Our Ref: AB/14/19/HH
Your Ref:

Town & Country Planning Act 1990 (as amended)
Town & country Planning (Development Management Procedure) (England) Order 2015
Application for Planning Permission for Works or Extension to a Dwelling

Development Bespoke lean-to to be constructed to the rear of the property and balcony conversion to include a bespoke apex structure and under-balcony conversion.

Location Mews House London Road Arundel

Location Plan for 3958 - Gray

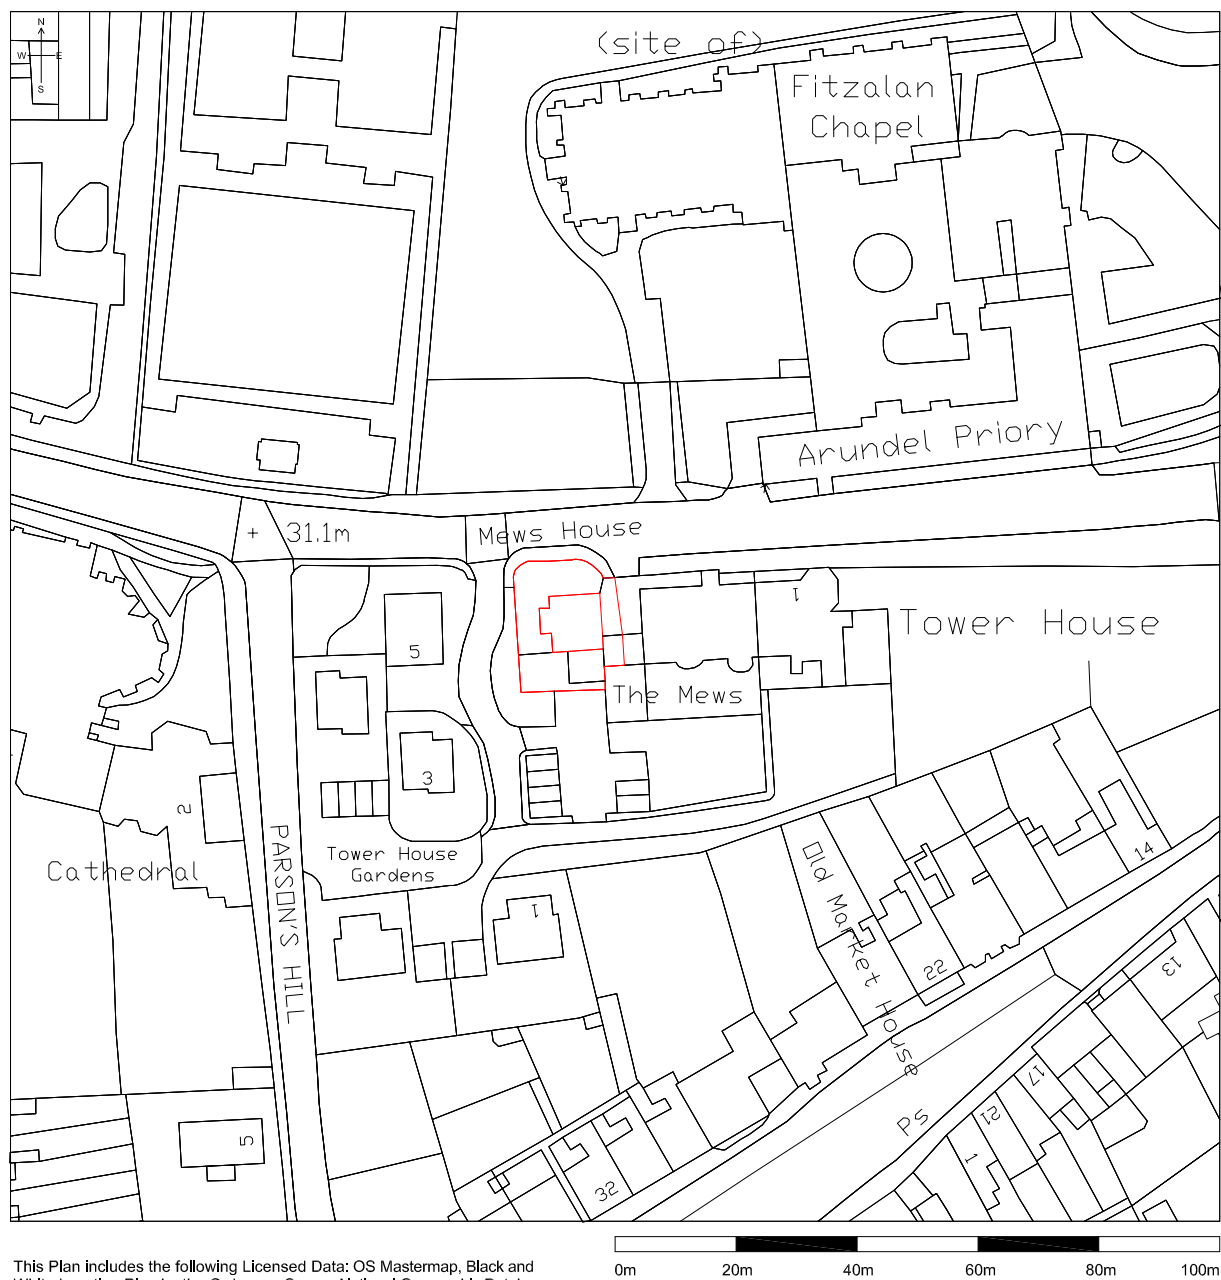
Location Plan: The red outline on the location plan needs to be a solid red outline it is currently incomplete.

Site Plan / Block Plan for 3958 - Gray

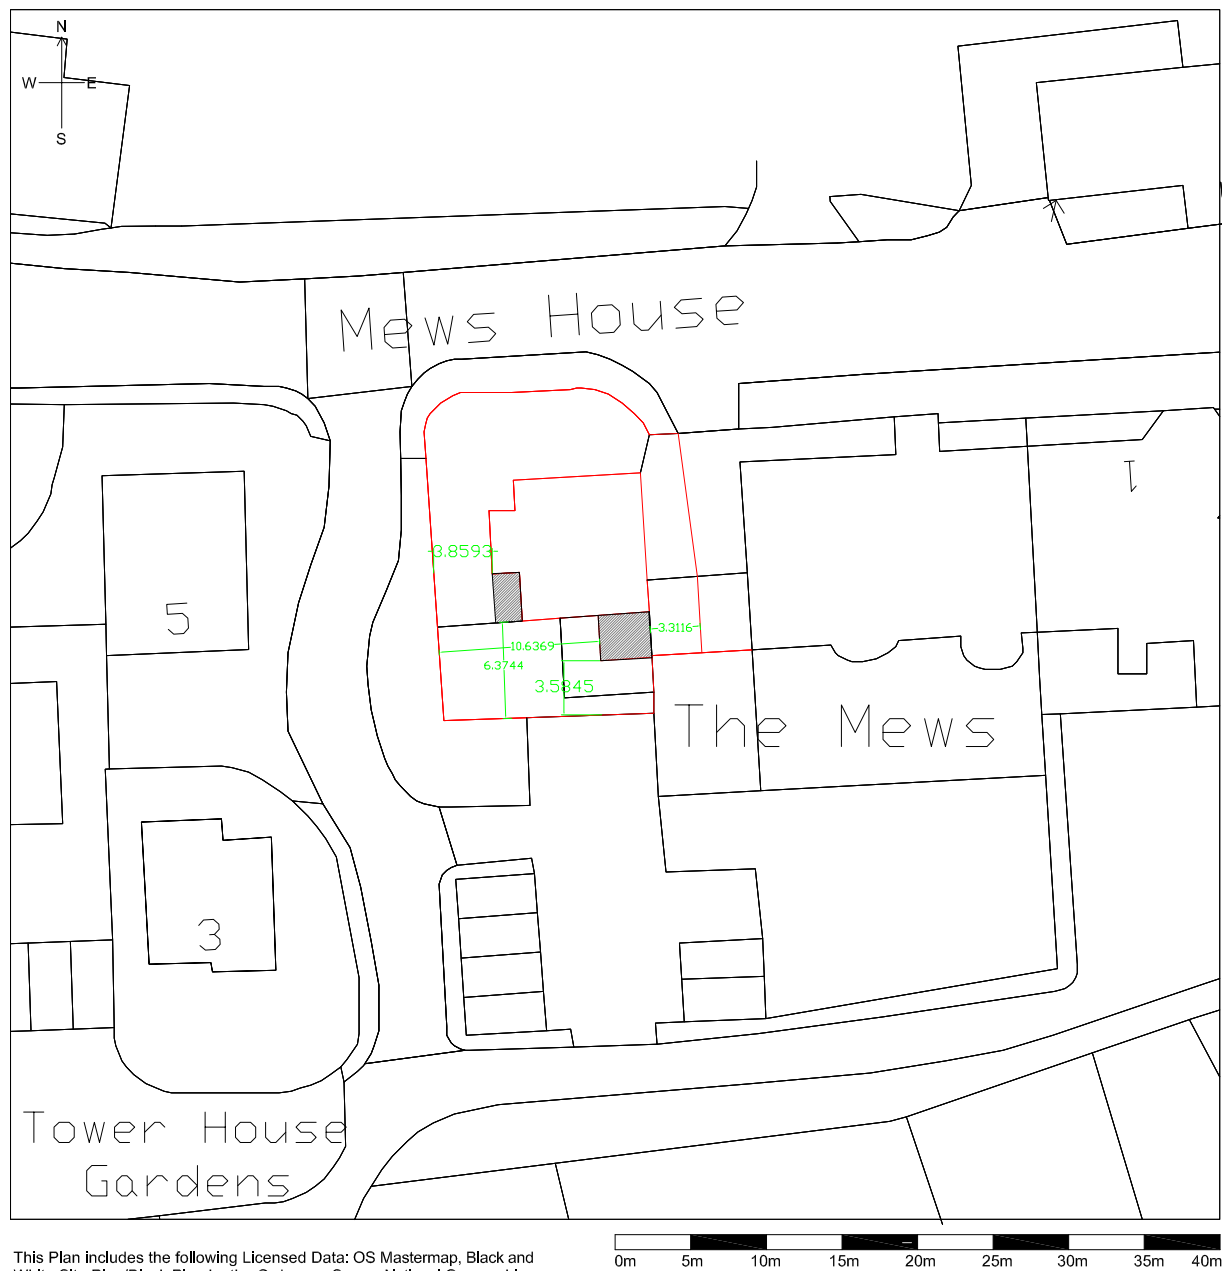
Block Plan: Please submit 1 electronic or 3 paper copies of a block/site plan which includes all dimensions from the proposed extension to all site boundaries.

MPS		PROPOSED PLAN	14/01/19	A
DRAWN	CHECKED		DATE	REV
CLIENT		PROJECT NUMBER		
MR S. GRAY MEWS HOUSE LONDON ROAD ARUNDEL BN18 9BH		3958		
		REVISION		
		A		
DRAWING REFERENCE		LOCAL COUNCIL		
3958/005/A		ARUN DISTRICT COUNCIL

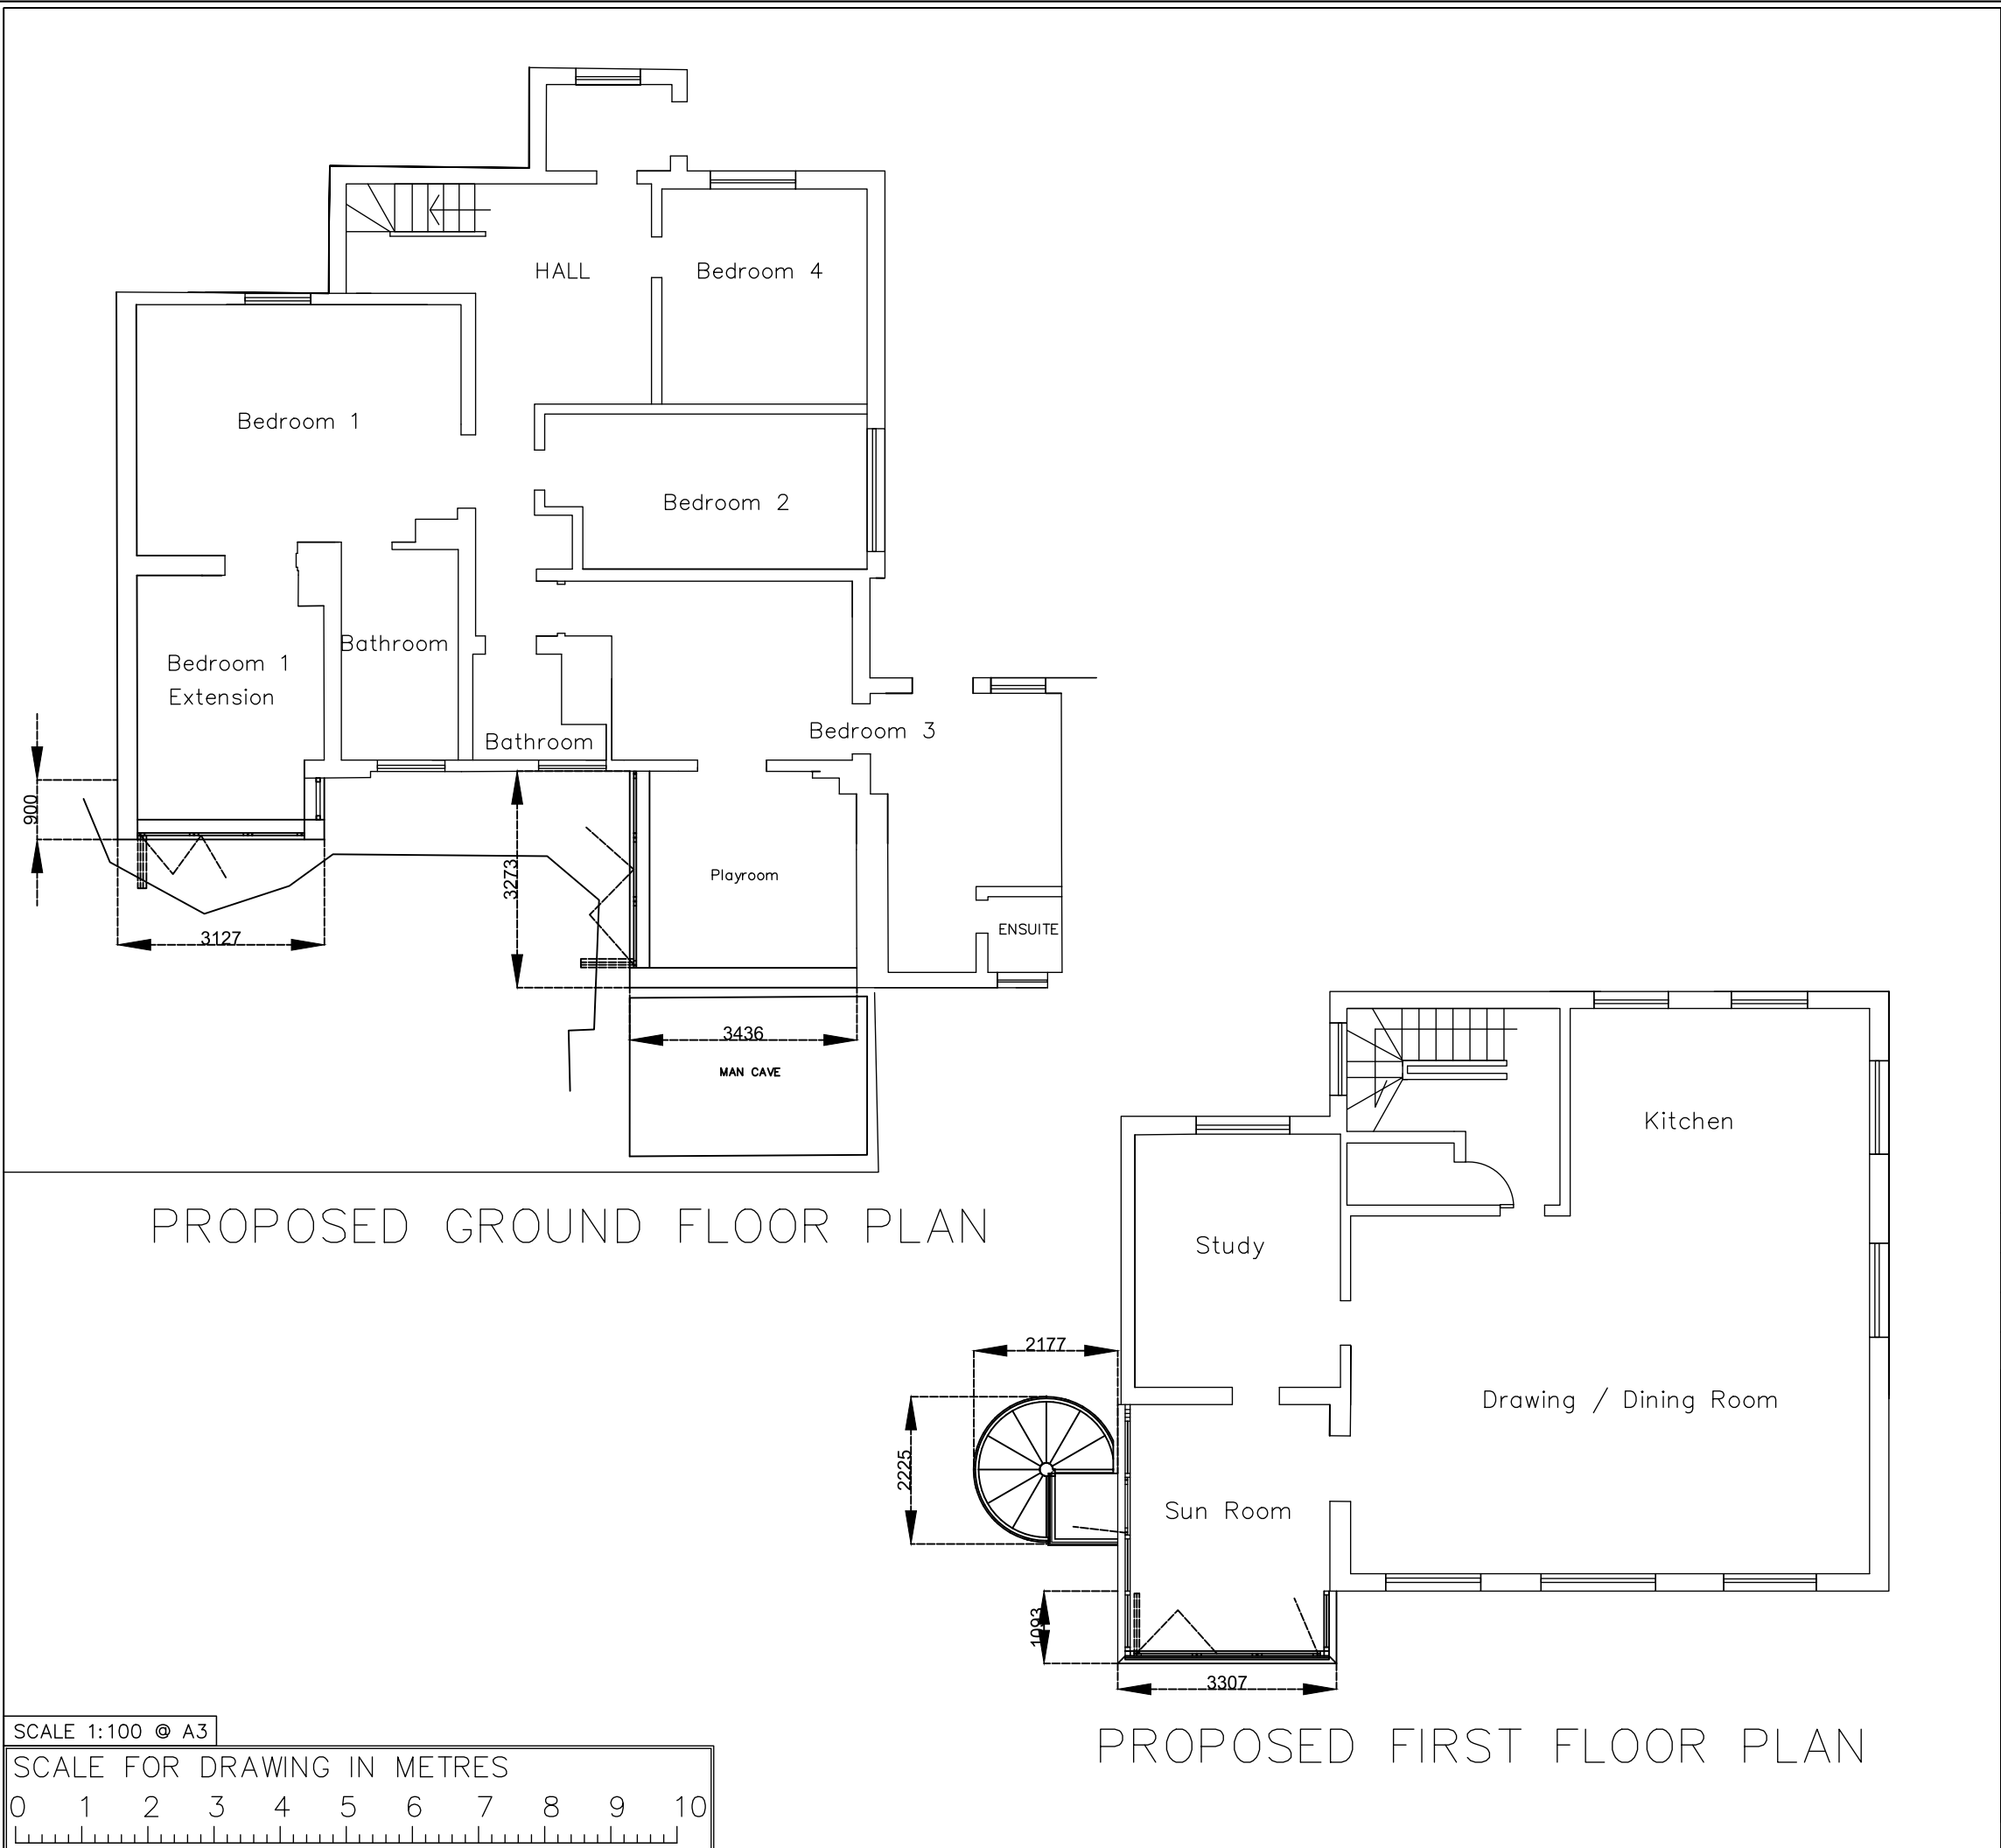
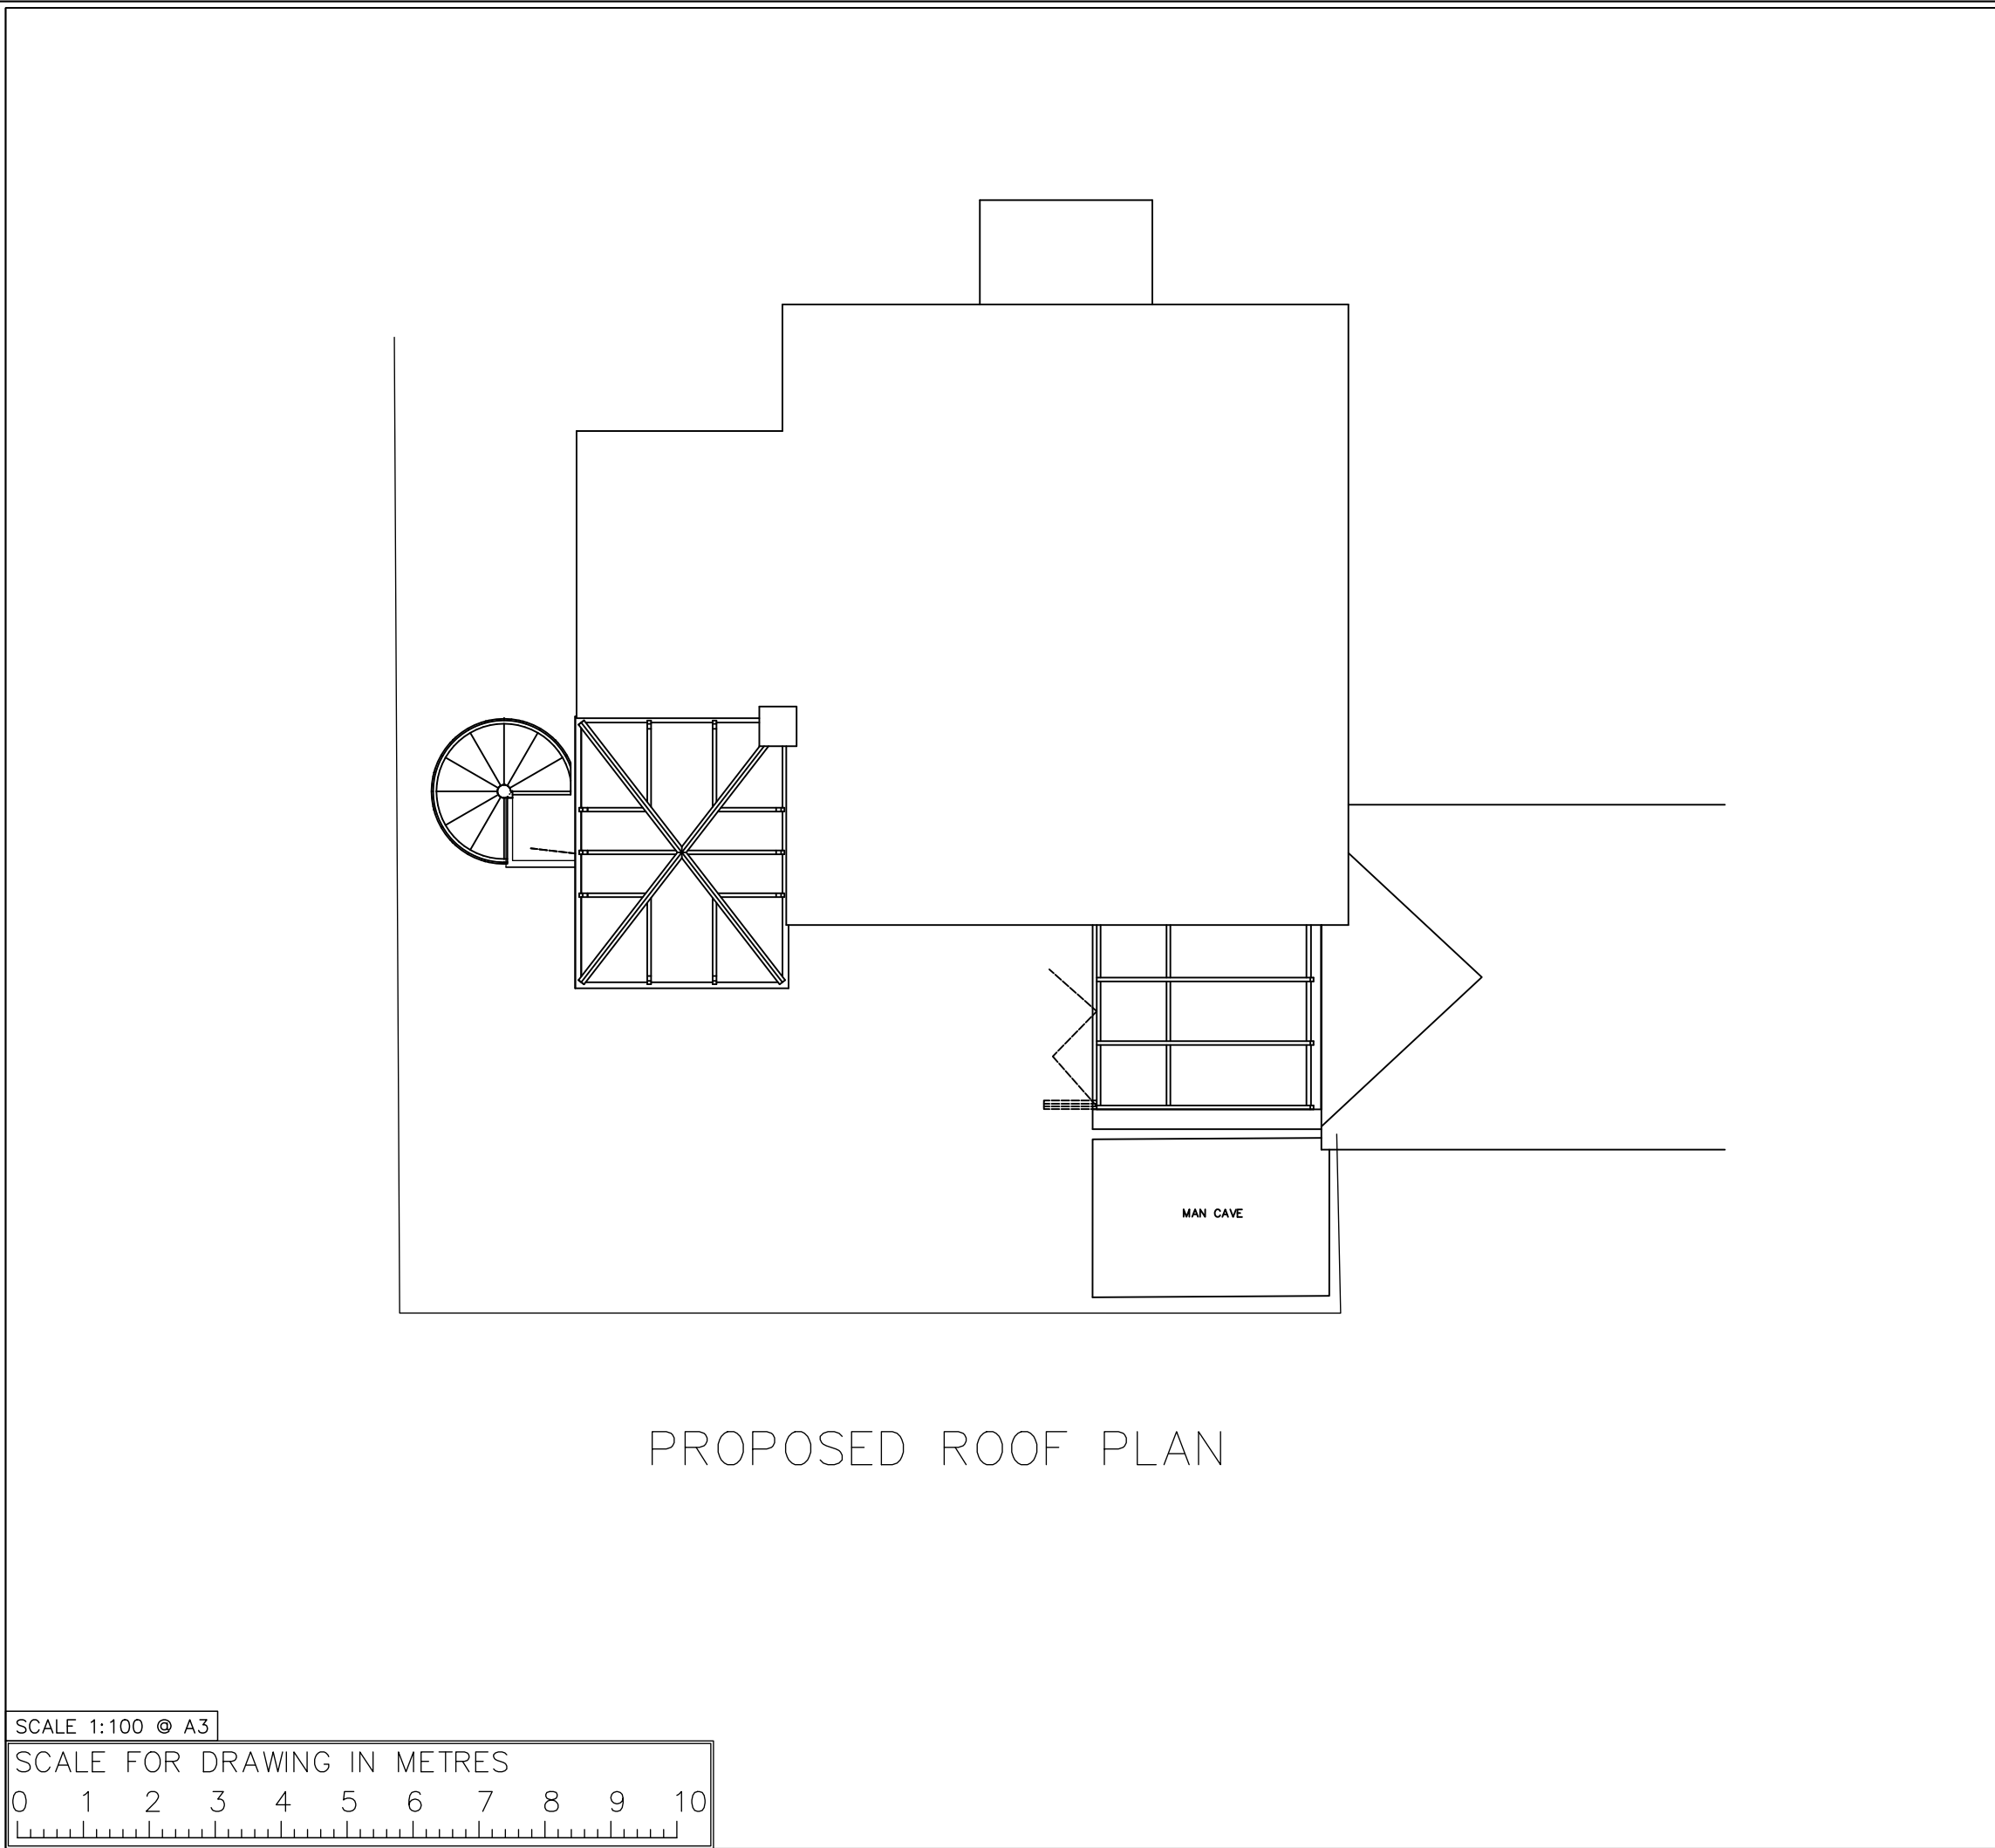
Room Labels: Please provide room labels on the proposed extension.

Floor Plans: You are required to complete the gaps on the floor plans as it is currently unclear what is the internal/external layout.
